## 7.16.19 Planning Div. Comments on MMC Sound Management Plan (rev 6/19/2019)

The City engaged a Peer Reviewer (Principal Consultant at HMMH) to review the submitted *Plan*. The Peer Review comments were given to MMC in March, 2019 and the city requested that the *Plan* be revised to address the Peer Review concerns. The current revised *Plan* was received June 19, 2019 and our review has concluded that it does not address all of the Peer Review comments nor all of the city's specific requests as set out in e-mails dated 11/14/18 and 3/19/19. The comments below summarize the key outstanding issues.

Fig.4.5 Proposed Flight Routes for the new MMC Helipad

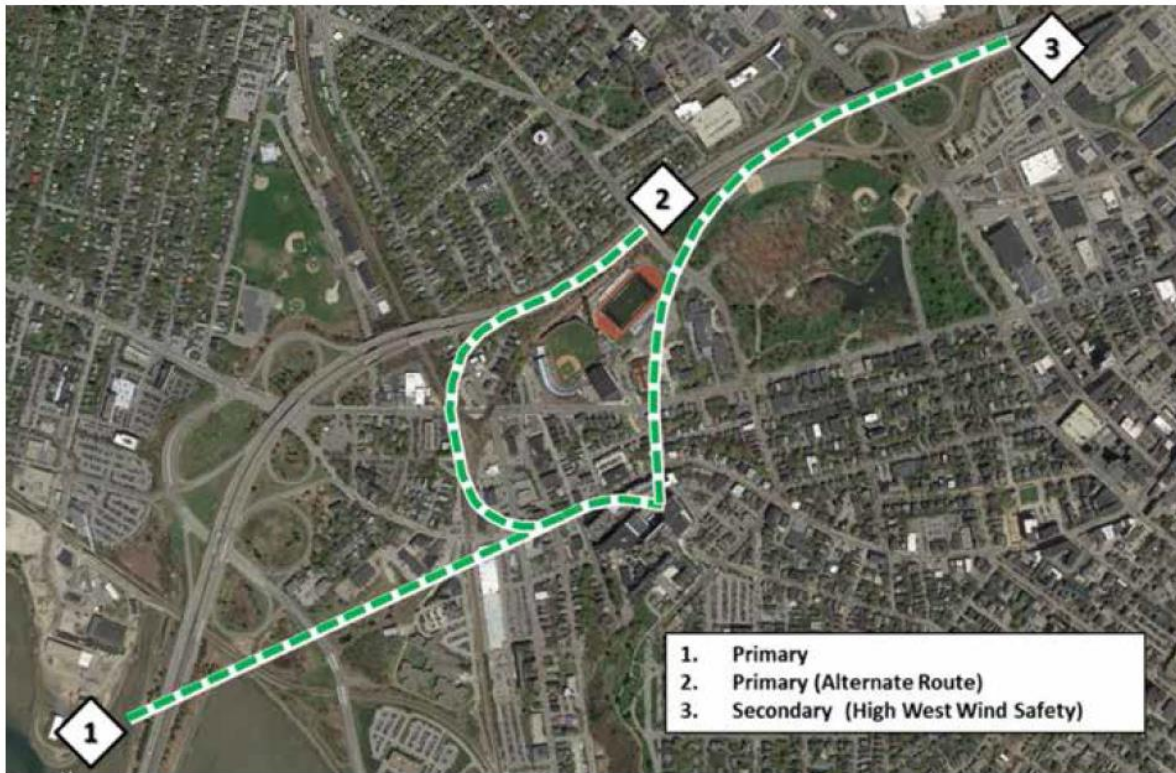
9. Monitoring and triggers for assessing implications of any changes: There are anecdotal observations that helicopters are currently using different flight paths from those confirmed in the IDP, and are operating at a greater frequency than has been advised during the review. The *Plan* should include some mechanism for monitoring both of these flight characteristics as from the start of operations at the new helipad, as these could generate unacceptable new sound levels for the surrounding residential neighborhood, including some properties not previously affected by the helicopters using the former helipad location (see IDP for discussions regarding flight paths).

**AG was aware that a few flights were not following the approved routes and thinks they are flights from Boston - is researching with Jetport/LifeFlight & will follow up\*. SMP to add confirmation that there is no intention to add any flight routes and confirm process if another route needs to be requested/ approved.**

If monitoring confirms that new flight paths over residential areas are being utilized and/or that the frequency of flights is greater than predicted, there needs to be a point identified which, if reached, would trigger a review of the helicopter operations to be undertaken in consultation with Life Flight and the city. This possibility should be acknowledged and addressed in the *Plan*.

*Appendix 6: 2017 Sound Study Measurement Locations*

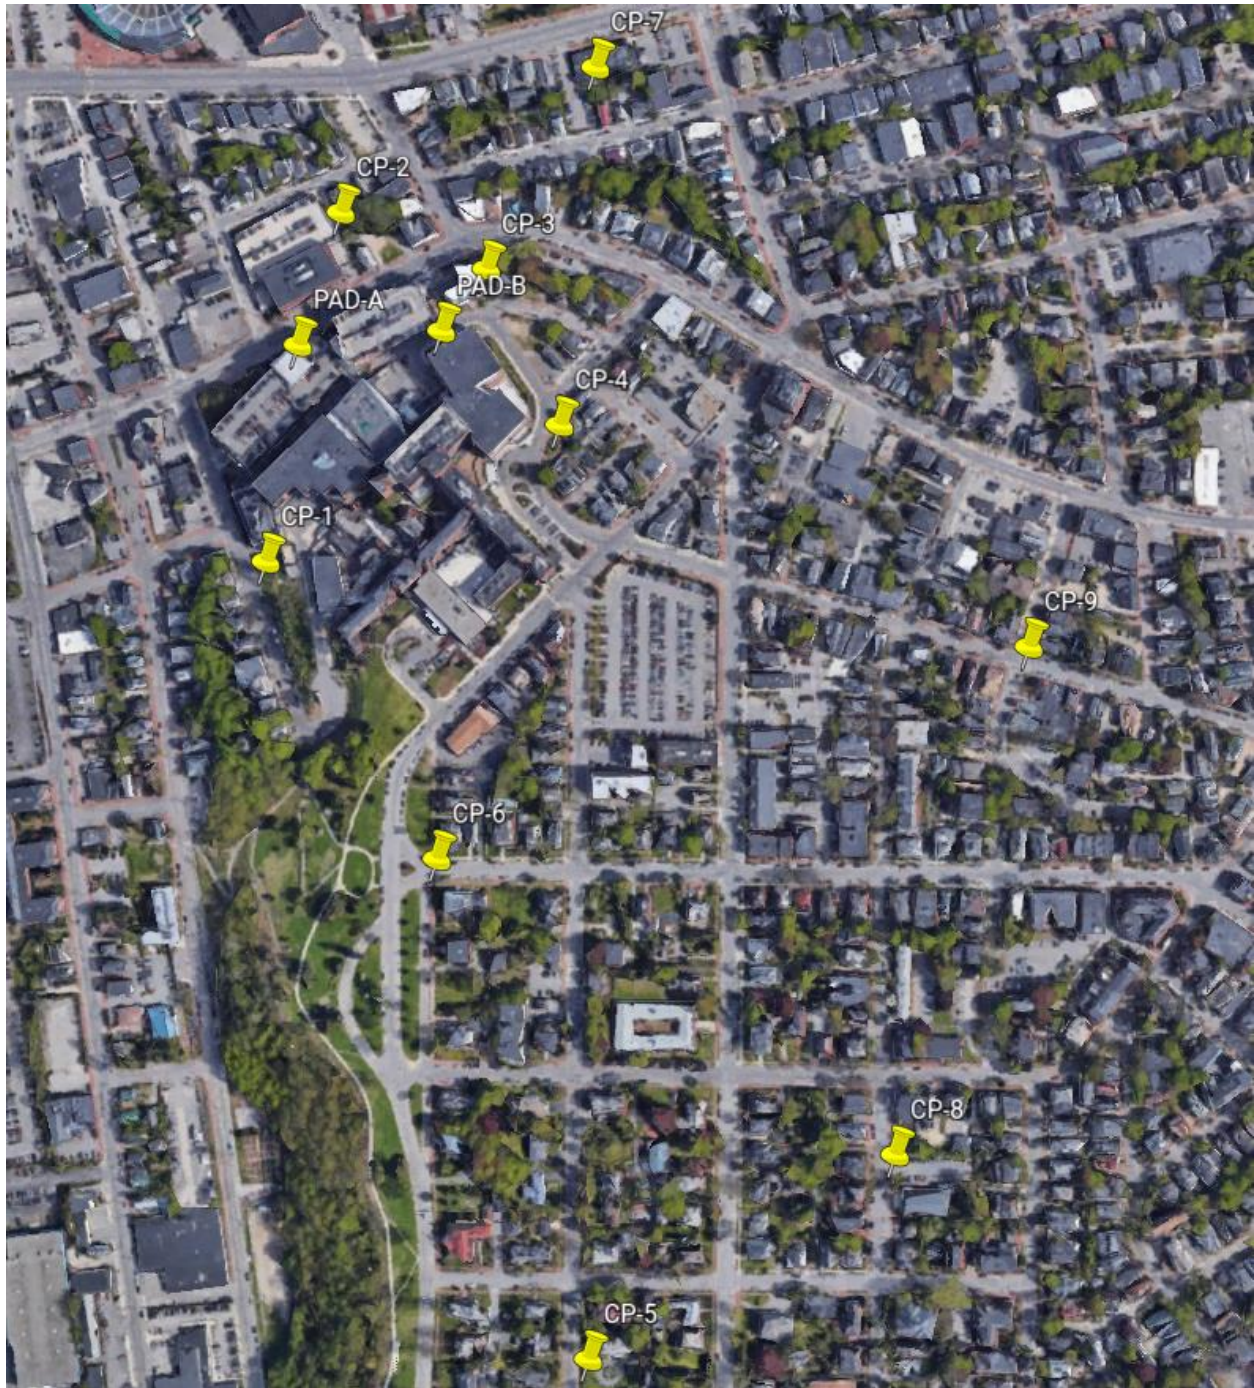
3. Location of Sound Devices - the *Plan* addresses the Peer Review suggestion to add in a tenth location but does not include the data from this location. See note below in #5.- AG considers this difficult and not helpful

5. Helicopter Test Flights: All flights, including for new location 10, should be completed as part of the current study with results included in the *Plan* as a baseline against which evaluation of complaints and monitoring can take place (see below). AG feels suggested location does not add /help & would have to shut down the construction site to do the tests now; JF agreed may not be essential & will discuss further with Peer Reviewer.
